National Grid has issued a paper entitled “Document: 8.4.12.2 Response to ISH2 Action Point 27 – Masterplans” – Planning Inspectorate Reference: EN020027. Appendix D is supposed to show opportunities close to the EACN at Ardleigh, and purporting to set out plans to introduce tree planting and other mitigants. The owners of the Grade 2 Listed Heritage Asset, [REDACTED] Farm, situated in Hungerdown Lane, Ardleigh, and with a boundary of just 10 metres away from National Grid’s boundary (order limits) are, once again, extremely concerned to note the lack of any form of realistic mitigation. [REDACTED] Farm is shown as having a border of woodland on two of its boundaries as was planted by the current owners approximately 35 years ago. However, it should be noted that the trees are 95% deciduous, and will provide no protection against noise pollution during the winter months. They will also provide little mitigation against the five 50 metre high pylons that will loom over this Grade 2 Heritage Asset (Pylons TB1, TB2, TB3, TB4 and TB5). They provide no mitigation for the actual house forming part of the heritage asset.

Action Point 27: Ardleigh & Little Bromley – Draft Opportunities Plan

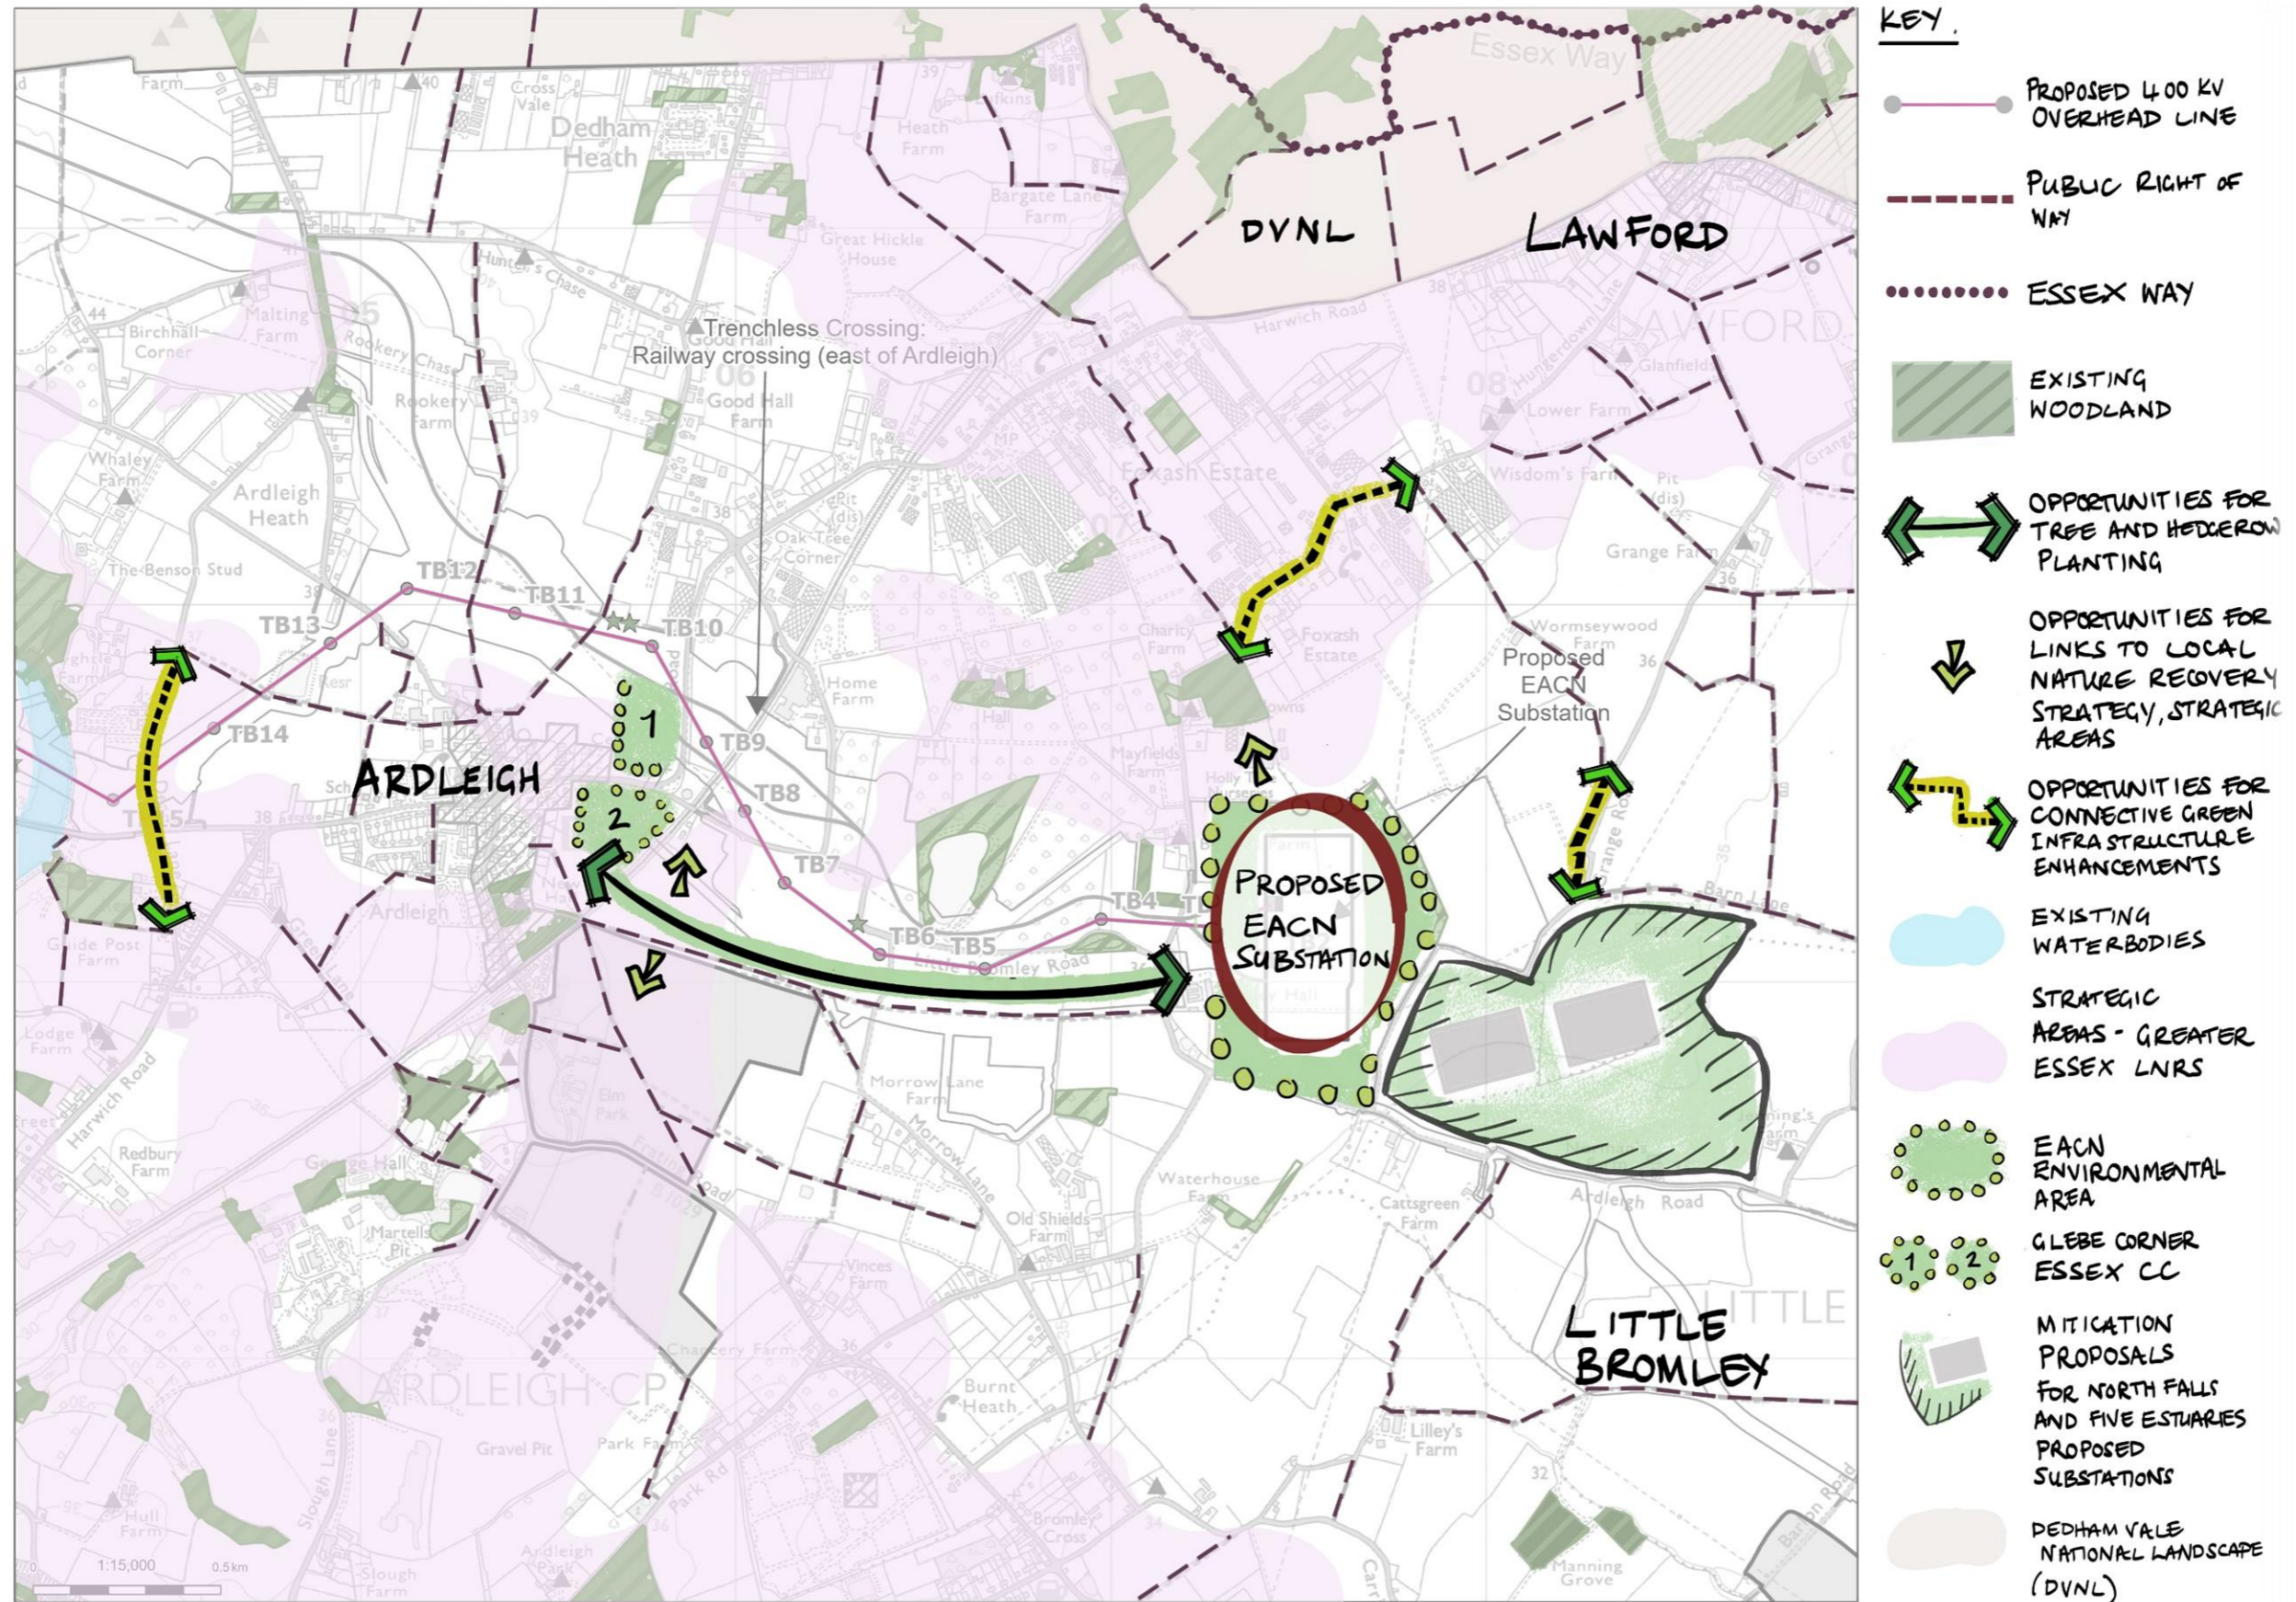
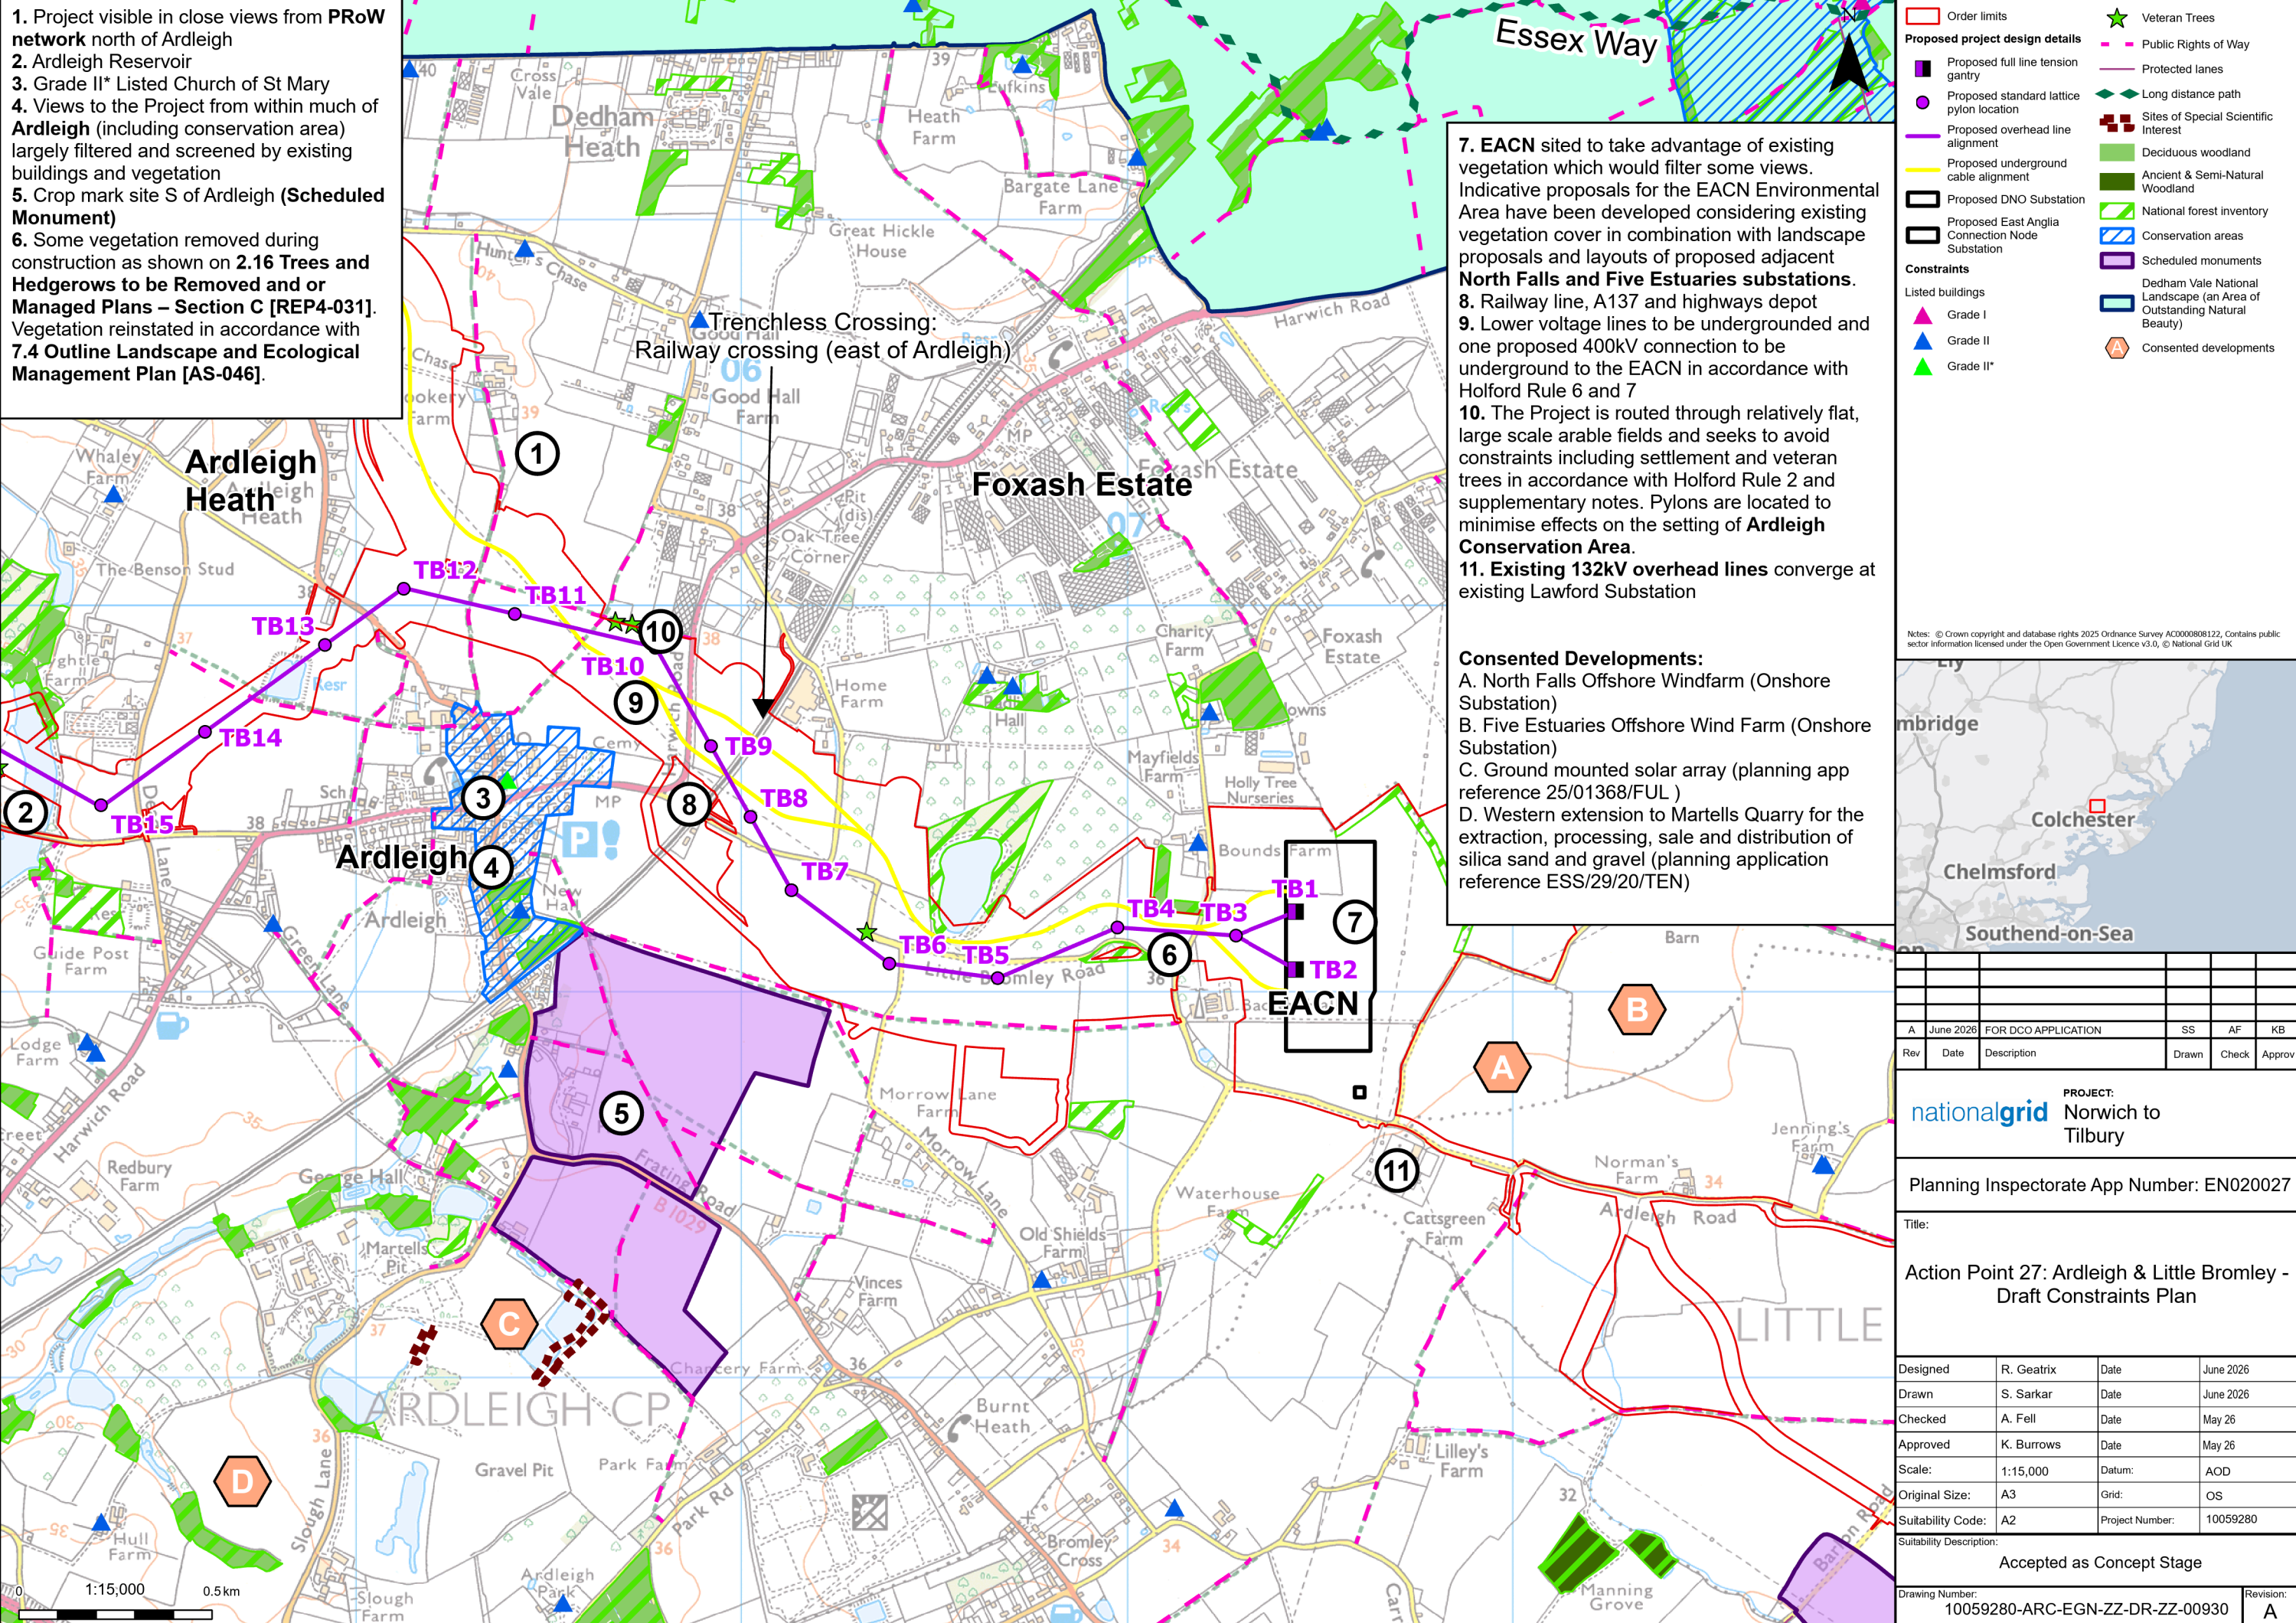
The proposed EACN substation is shown on National Grid’s “Action Point 27: Ardleigh and Little Bromley – Draft Opportunities Plan” as being surrounded by the EACN Environmental Area. As this Environmental Area is immediately opposite, extremely close to and in full view of the Grade 2 Heritage Asset, [REDACTED] Farm, the EACN Environmental Area should be specifically stated. To call it just the EACN Environmental Area” and to show a pretty picture with green colouring is far too woolly.

National Grid has previously conceded that they see no possible way of mitigating the impact on [REDACTED] Farm, which is a Heritage Asset. The owners of the property have proposed that the EACN be moved some 300 metres to the east, which would give some relief. However, NG has not responded to this suggestion. Nor have they responded to the suggestion that the EACN substation be built underground to reduce noise. This is despite National Grid’s evidence to the DCO examination document 6.14.A3 which described [REDACTED] Farm as “the worst affected Noise Sensitive Receptor” affected by the Scheme. It concludes that the specific sound level at [REDACTED] Farm is predicted to exceed the night time background sound level by 14dB unless mitigation is put in place.

There has been no mention of the wirescape that will be completed by the siting of the EACN substation, next to the North Falls and Five Estuaries onshore substations, together with the existing 132kV pylons and power lines feeding the substation at Lawford. Indeed, it is ironic that NG have described the site for the North Falls and Five Estuaries substations as being an area of “mitigation proposals” without explaining what these words mean. Why not be upfront and call the whole area a wirescape.
